Rezoning Transportation Analysis

Petition Number: 2023-043

From: Jake Carpenter, PE
Jacob.carpenter@charlottenc.gov
980-221-5675

Date	Description
7-26-23	First Review (PM)
9-19-23	Second Review (IW)

EXISTING CONDITIONS PLAN AN TECHNICAL DATA SHEET
REZONING PETITION: 2023-043

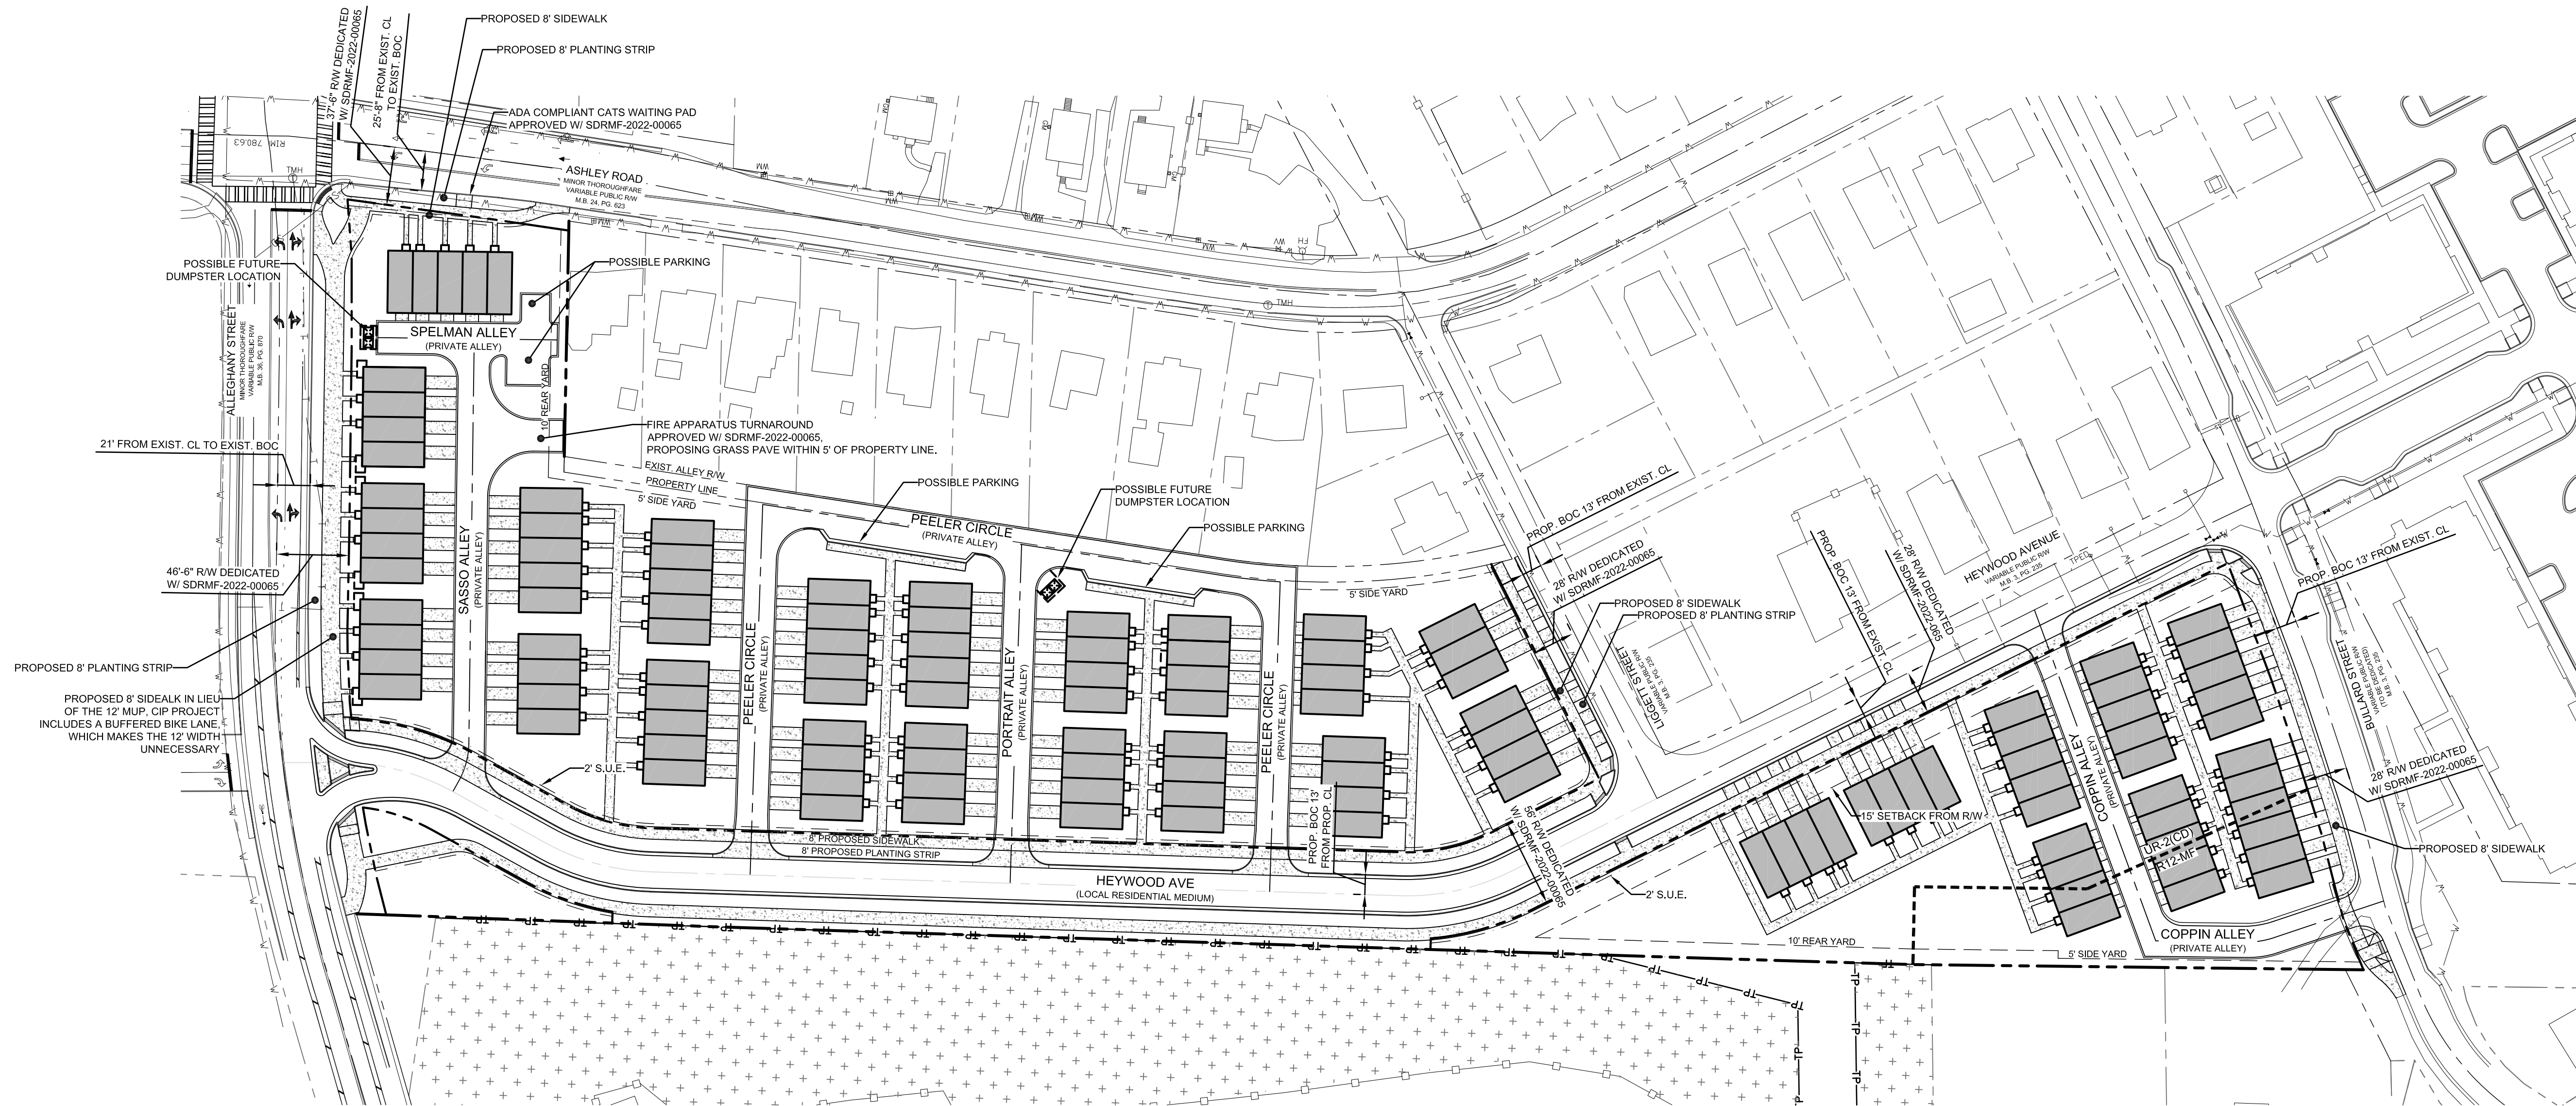
either removing or relocating the proposed fence on the east side of the proposed private alley 3, including the CDOT standard notes, and dimension the future back of curb from the centerline on each public street. Further details are listed below.

- a. **Proposed Public Street A:** New local residential medium street, back of curb located 13' from the centerline.
- b. **Alleghany Street:** Future back of curb located 27' from the centerline to accommodate a roadway cross section of a 2+lane avenue with buffered bike lanes.
- c. **Ashley Road:** Future back of curb located 21.5' from the centerline to accommodate a 2 lane avenue with buffered bike lanes.

Clarifying Comment 9-20-23: Label and dimension the future curb and gutter from the centerline for each road on the site plan.

- ~~5. Revise conditional notes to include all previous Transportation commitments from RZP 2021-133.~~
- 6. Outstanding Comment from 7-26-23:** Revise site plan and conditional note(s) to remove the fence completely from the public alley and onto private property. If fence is to remain along the single family home side it needs to be completely on private property.
